Mountain View Electric Association, Inc. (MVEA) has these comments about the following:

Project Name: Pine View Estates Preliminary Plan

Project Number: SP 204

Description: Approval is being requested for a seven (7) lot residential development on approximately 39 acres in El Paso County. This parcel is located west of Ranch Hand Road and north of Hopper Road in Section 13, Township 11 South, Ranch 64 West.

PRELIMINARY PLAN

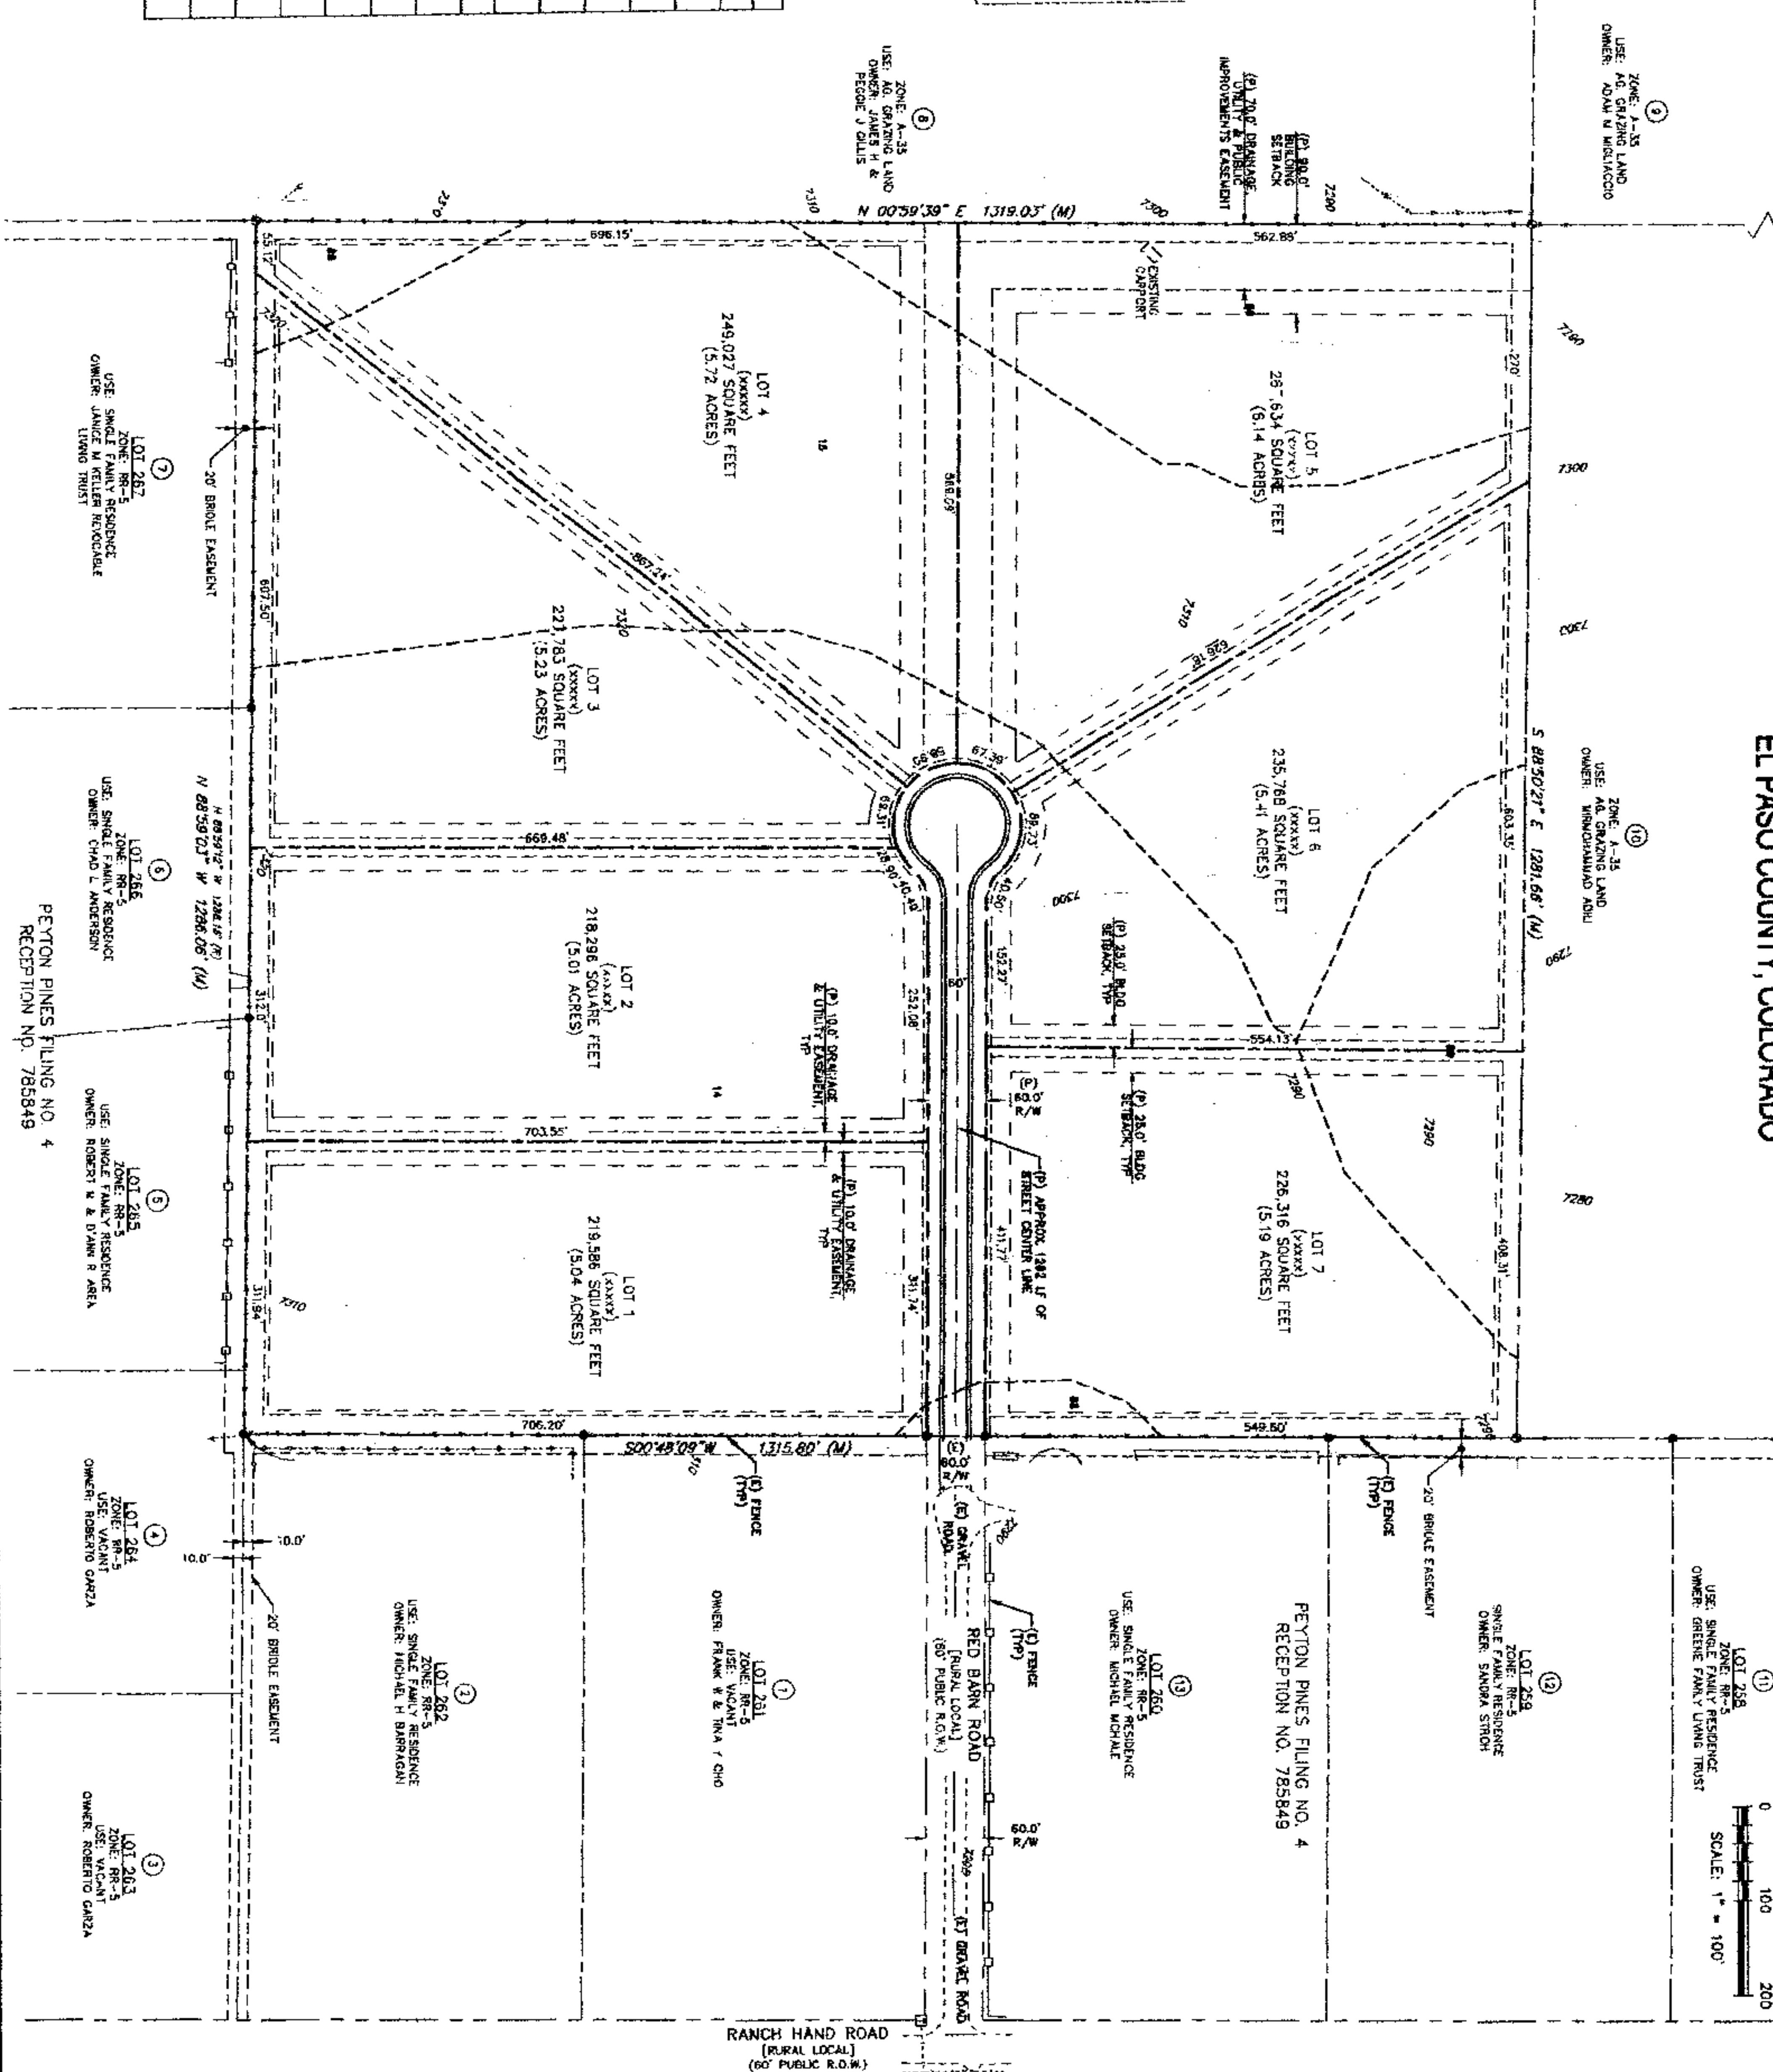
MVEA request utility easements of ten (10) foot front, side and rear lot line along with twenty (20) foot exterior utility easement. MVEA will request ten (10) foot utility easements on the lot side of the ingress & egress easement for the design of electrical facilities. Additional easements may be required in order to serve this development.
